Aquind Interconnector Nationally
Significant Infrastructure Project Examination: Deadline 3

Deadline 3 response from Winchester City Council

3 November 2020

Plate 1 - Plots 3-12 and 3-13 as shown on Land Plan as at Application

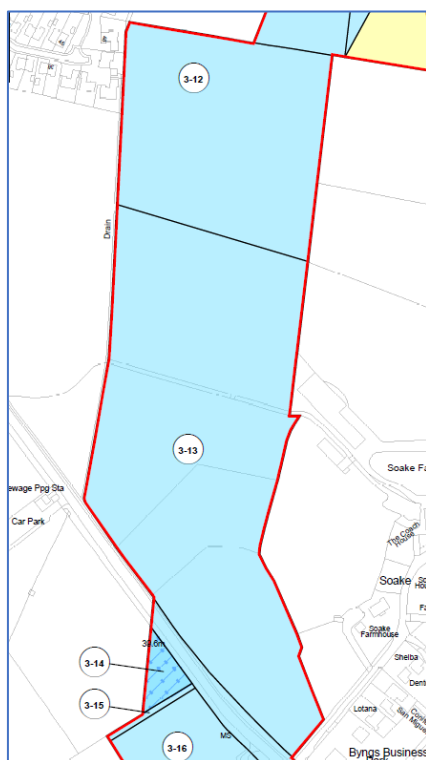
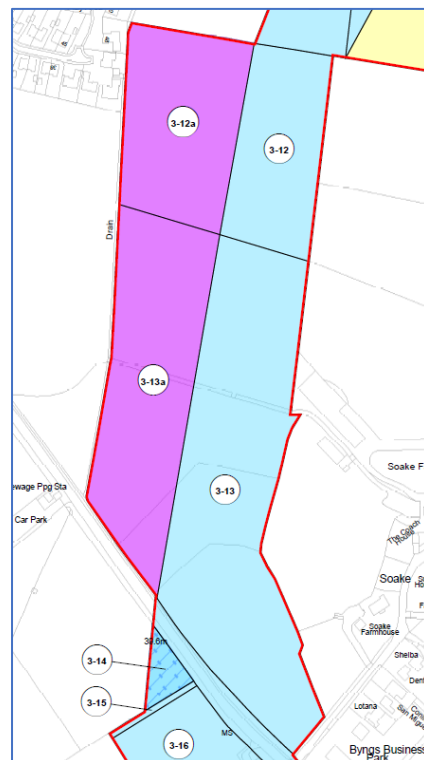
The Council has a concern relating to the adjustment to the Order Limit at Soake Farm as described in section 3.3.1.6. Plates 1 & 2 show the existing and proposed arrangement. Whilst the area where the cable is to be installed is reduced, section 3.1.1.9 indicates that New Access Rights are to be retained over the purple area and there is a reference to the provision of a haul route at the end of the paragraph. These are now shown as land parcels 3-12a & 3-13a on sheet 3 of the Lands Plan (REP1-011).

The nature and degree of access for monitoring (by foot or vehicle) needs clarifying but the Council would resist the establishment of any haul route from north to south. Such a provision is not compatible with the HDD approach to the installation of the cables in this location which includes two SINC's.
